Please ask for: Ms Iqraa Malik
Email: iqraa.malik@terraquest.co.uk
Telephone: 0121 234 1390
Our Ref: M/29/22/HH
Your Ref:
Date: 24th March 2022

Application for Planning Permission for Works or Extension to a Dwelling

Development: Erection of first floor side extension.
Location: Oakwood 102 Middleton Road Middleton-On-Sea PO22 6DL

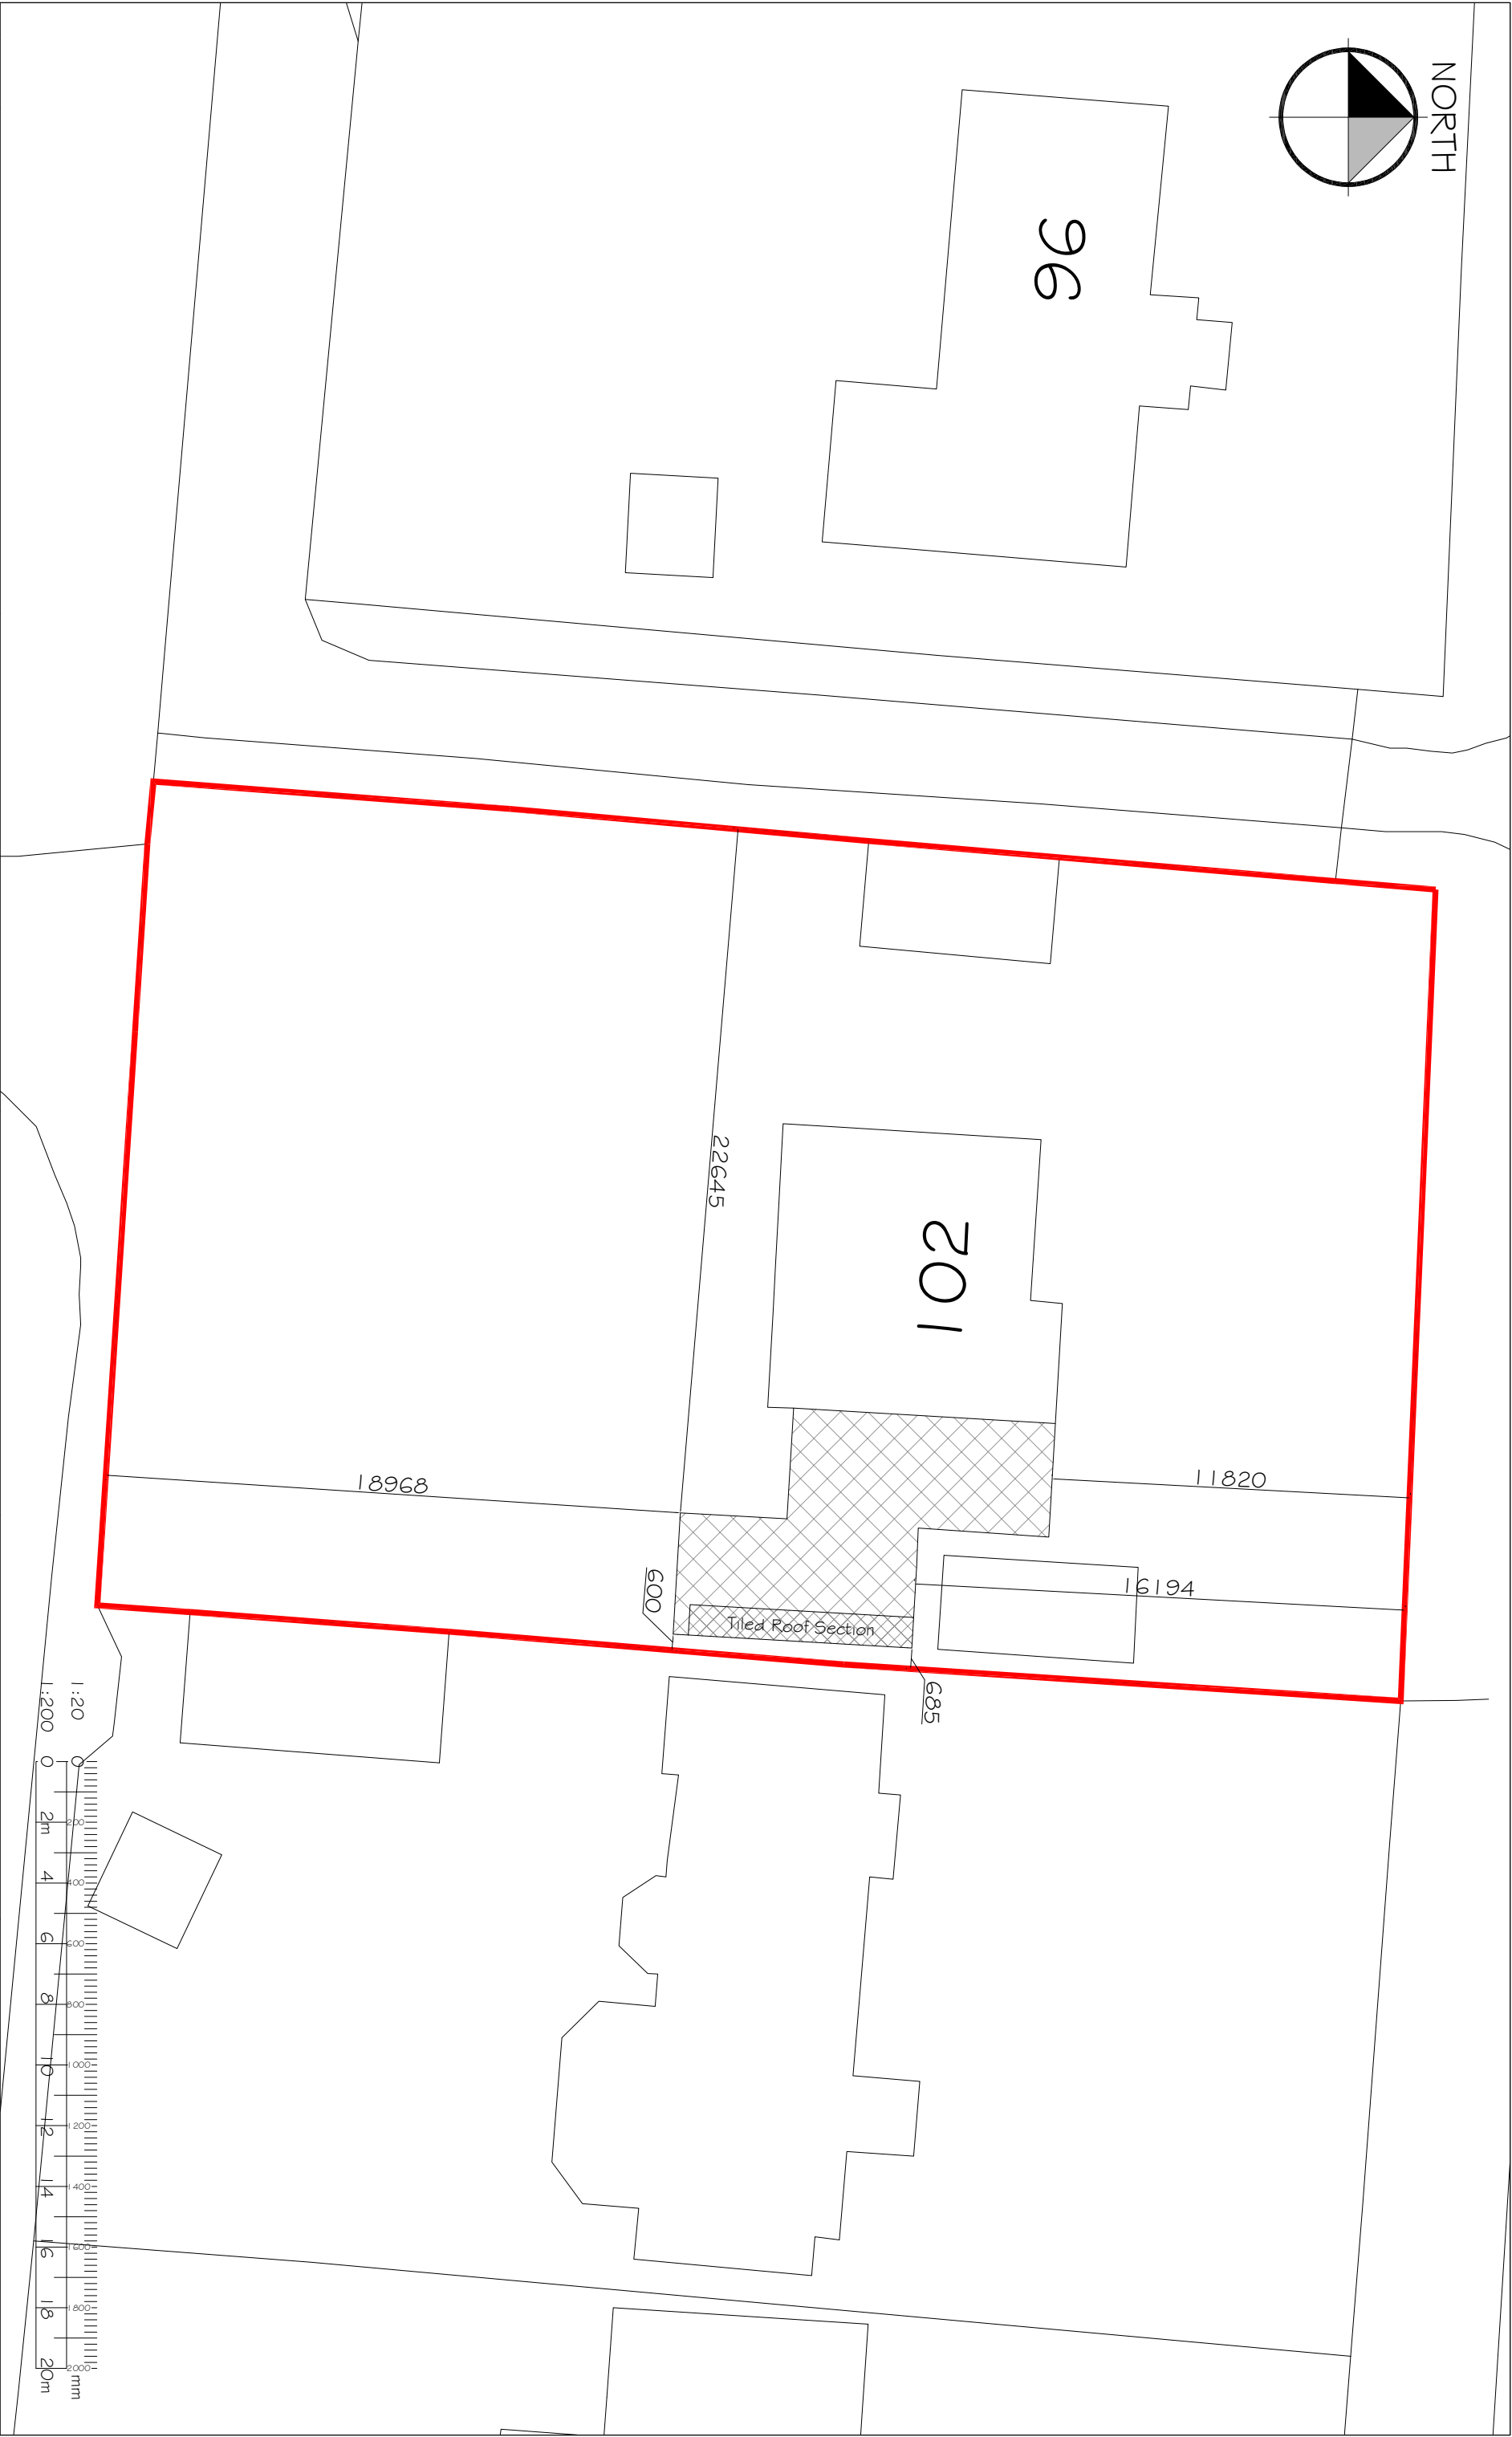
Block Plan

You are required to have dimensions from the proposed extension(s) to all site boundaries. Please amend.
